FIELD REPORT

Project **Jarco Drive (252)**
 Location **Fuquay Varina, NC**
 Client **Nichols Buildings, Inc - Owen Nichols**
 Contractor **Nichols Buildings, Inc - Owen Nichols**

ECS Project Engineer / Project Manager arrived on site to conduct a visual inspection of the structural metal building installation, siding and other miscellaneous structural members.

PHOTOGRAPH LOG
Steel Visual Inspection – Jarco Drive (252)
Fuquay Varina , North Carolina
ECS Project No. 33: 4336
07/18/2018

ANCHOR BOLT SUMMARY

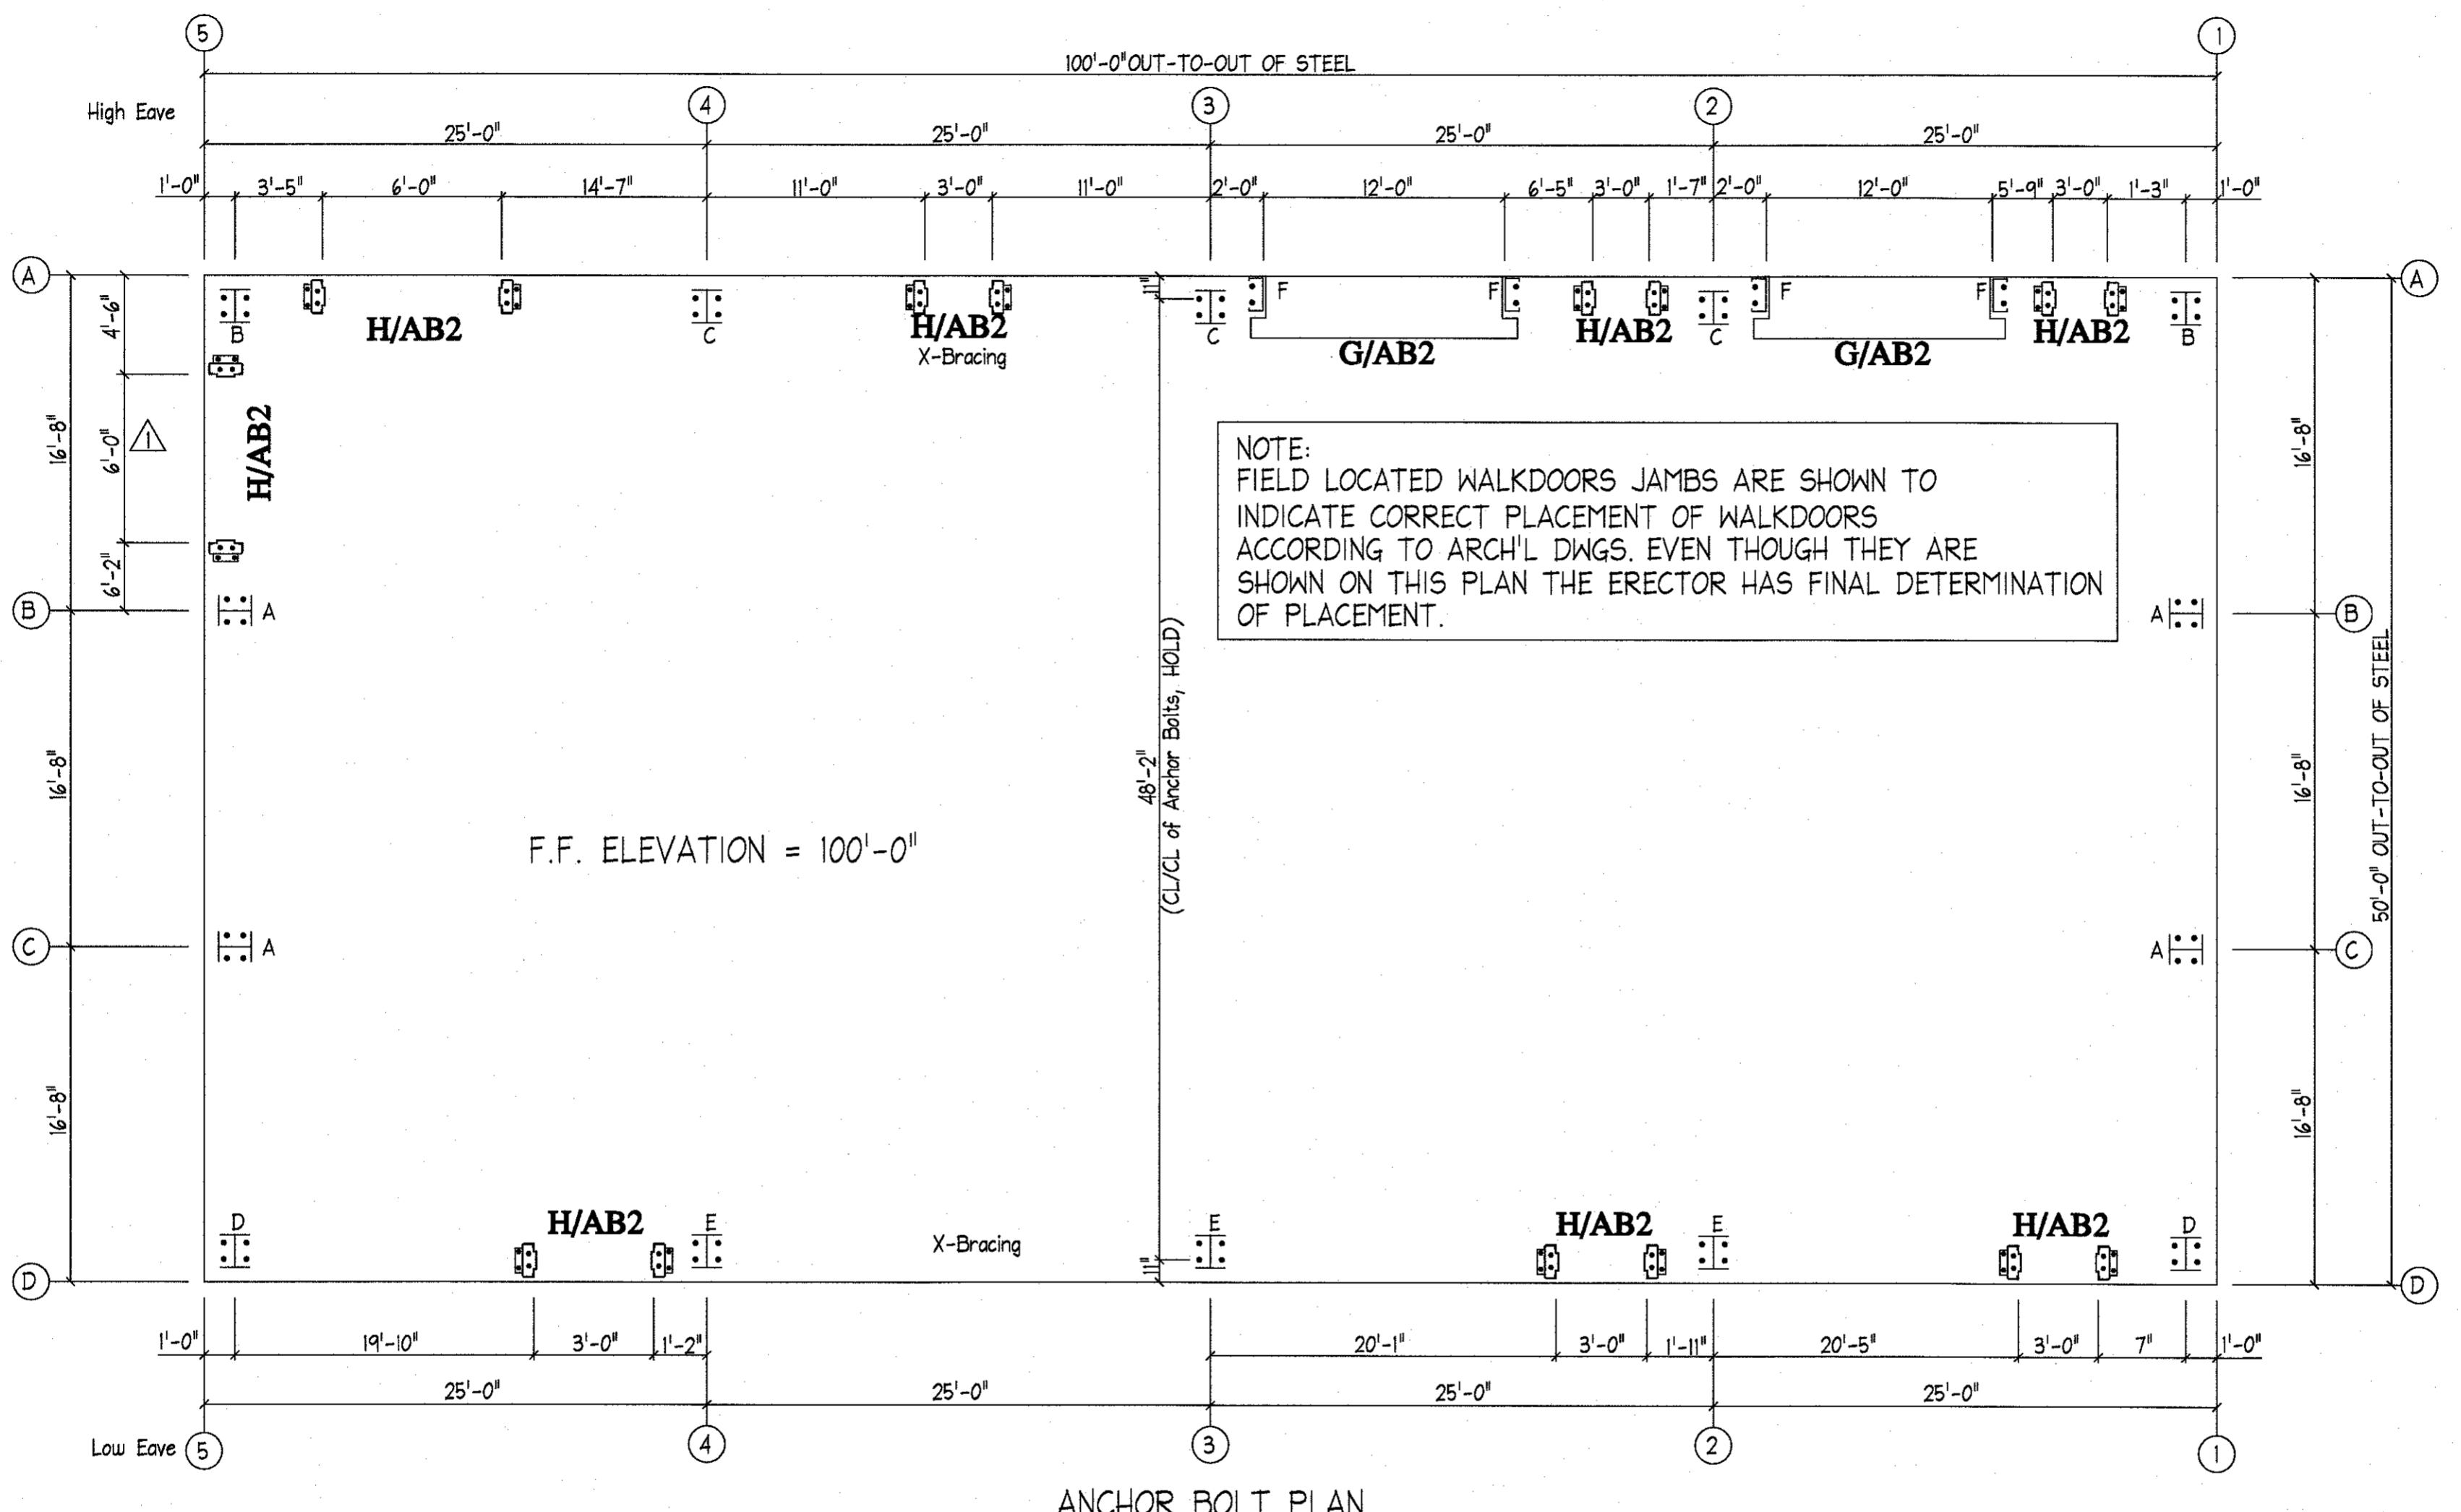
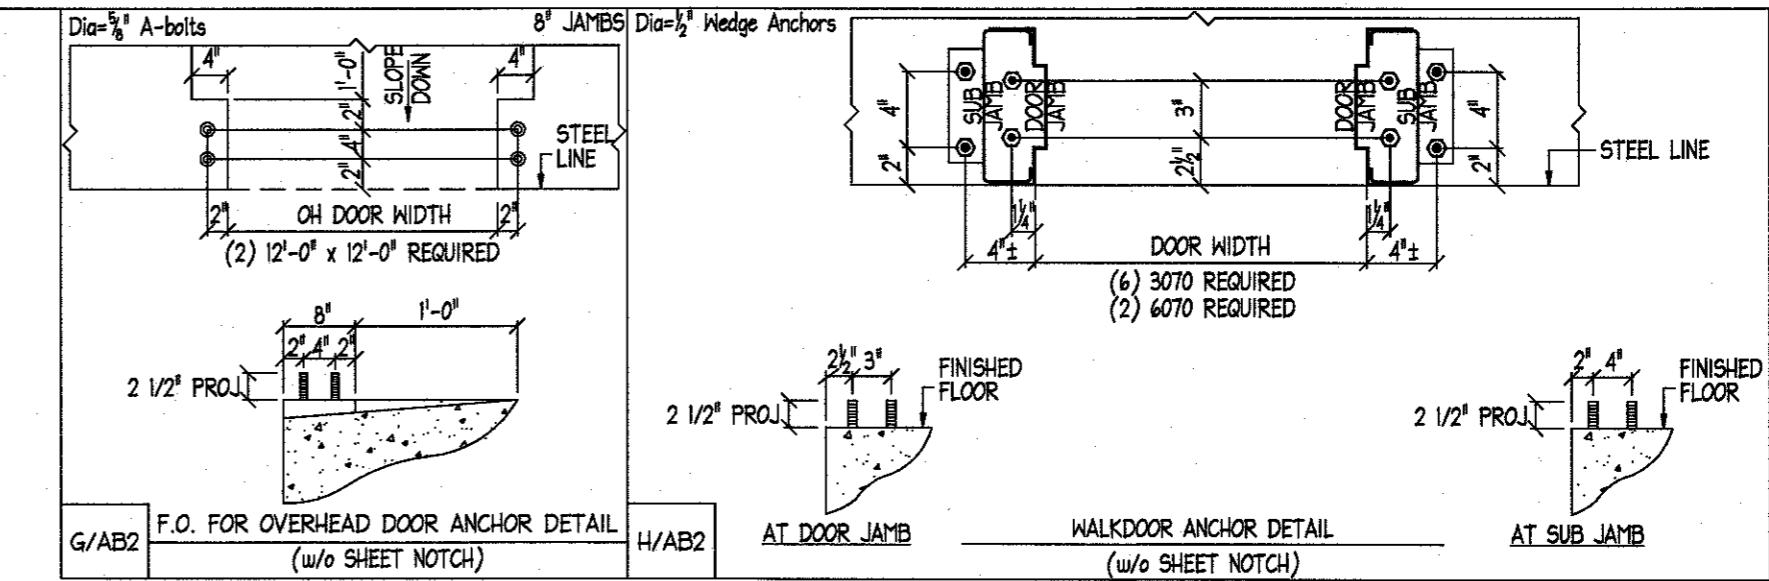
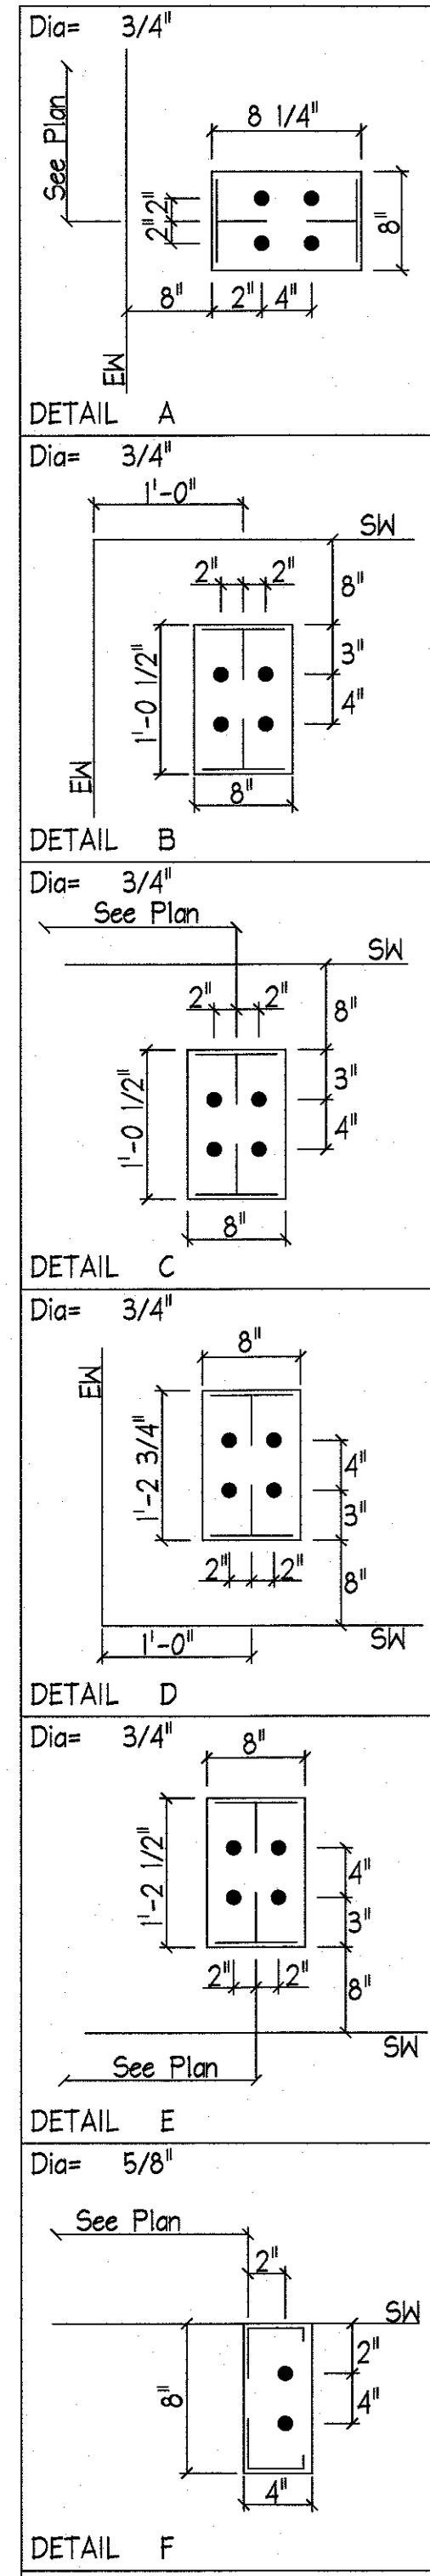
(1) Anchor Bolts on all Column bases has proper lengths, more than (1/2") bolt extrusion through the nut - Proper engagement.

ROOF FRAMING PLAN

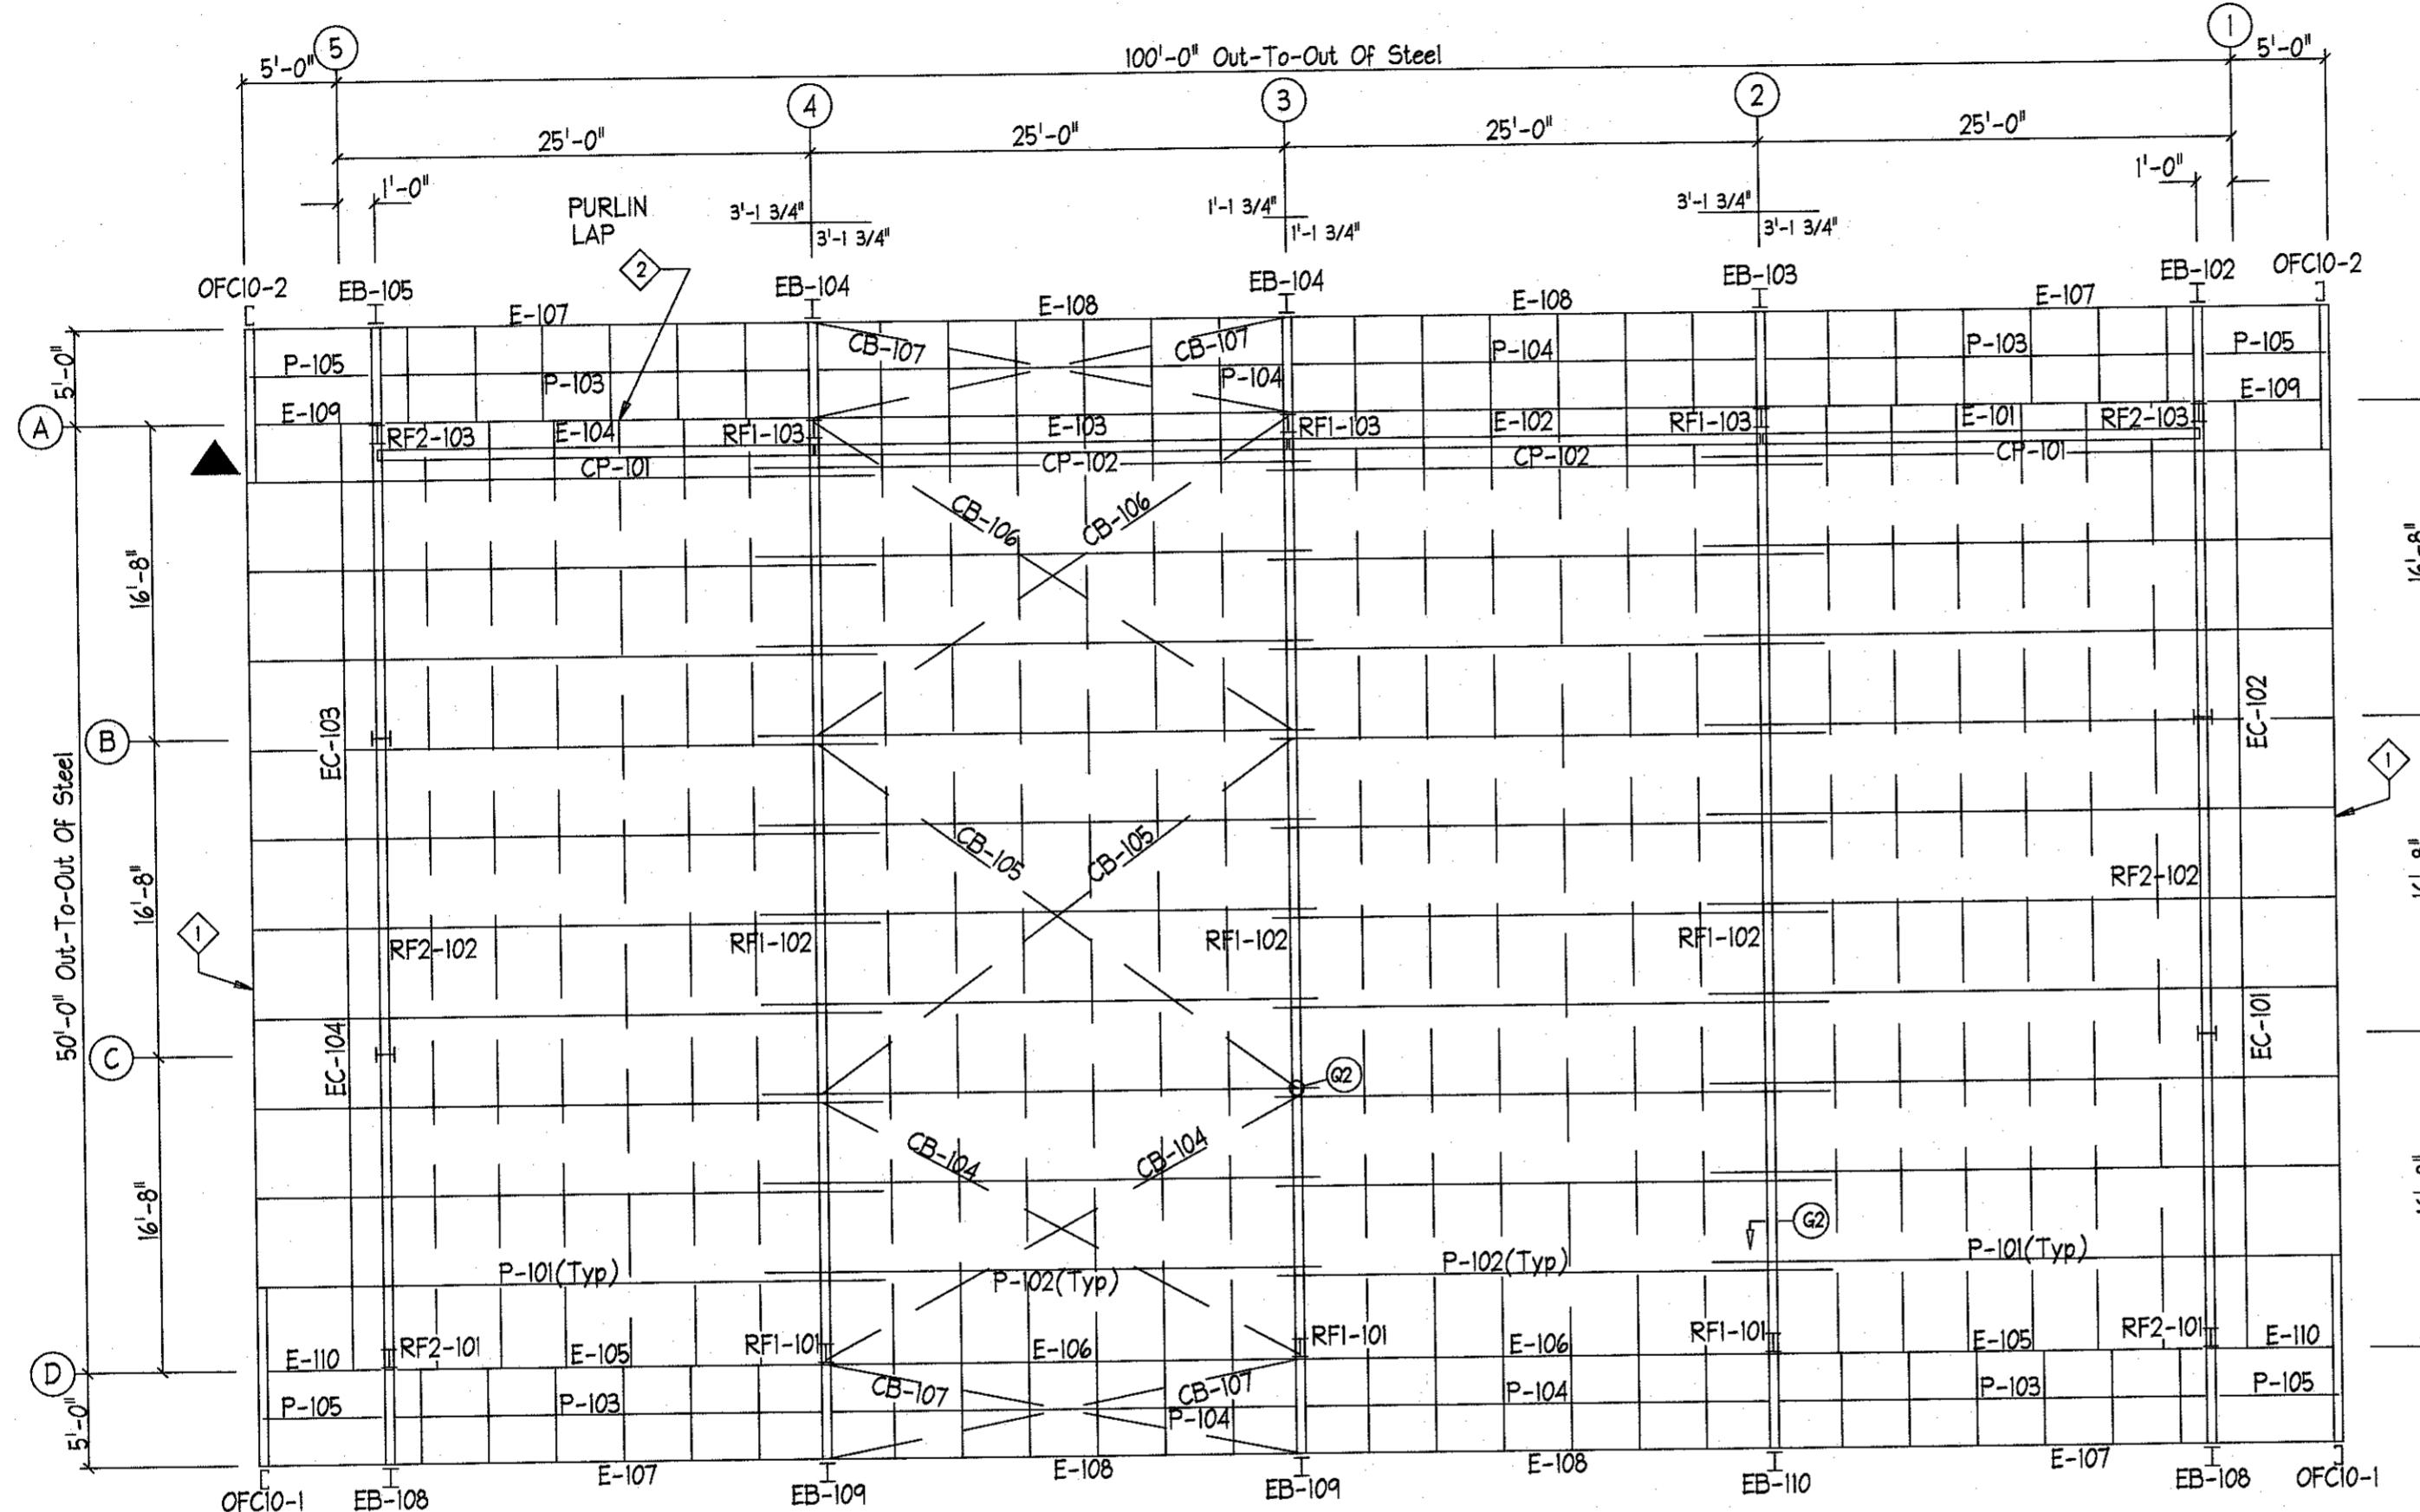
(2) All wire bracings on the roof and sides along column lines (4) and (5) were installed properly, however, the contractor needs make sure they are properly tightened for them to provide required lateral support.
